NORFOLK BOREAS

Oulton Parish Council's submission at Deadline 10

Figure 1 Proposed road regrading in proximity to the Old Railway Gatehouse

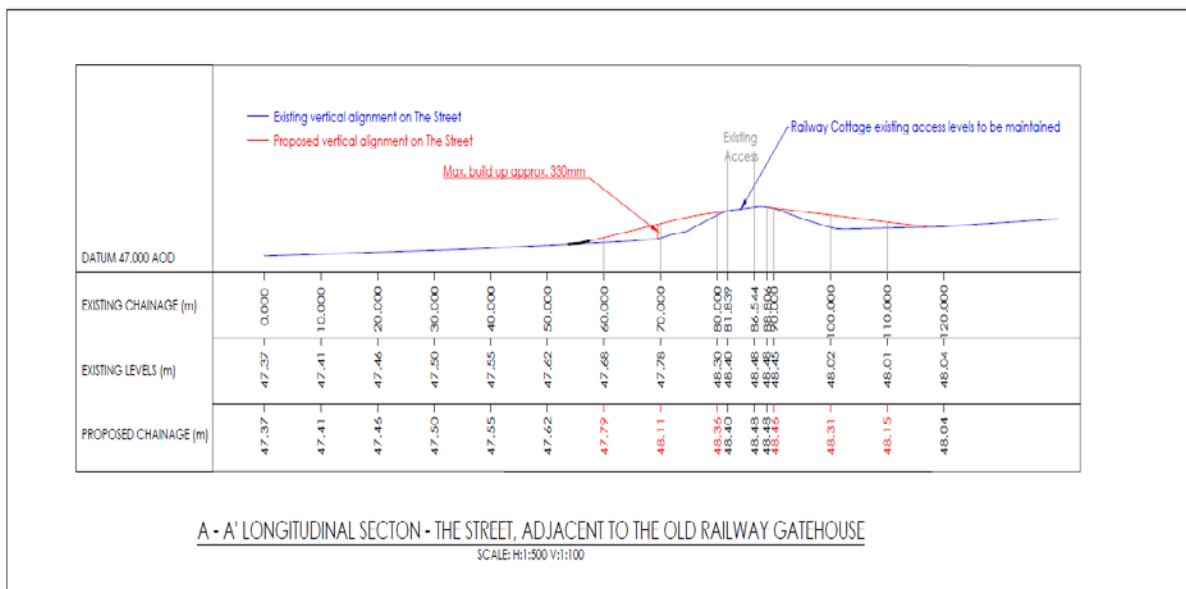
The Applicant's conclusion that, simply because of the introduction of a few passing places and the grading of a hump, the adverse effects of their additional traffic will be "non-significant," is breathtaking.

We understand that the residents are concerned that the current measures on offer only include acoustic glazing and the construction of a wall around the part of the property to the **south**, but no mention is made of the need for protection from noise and emissions at the **northern** end of the property, where the need is just as acute.
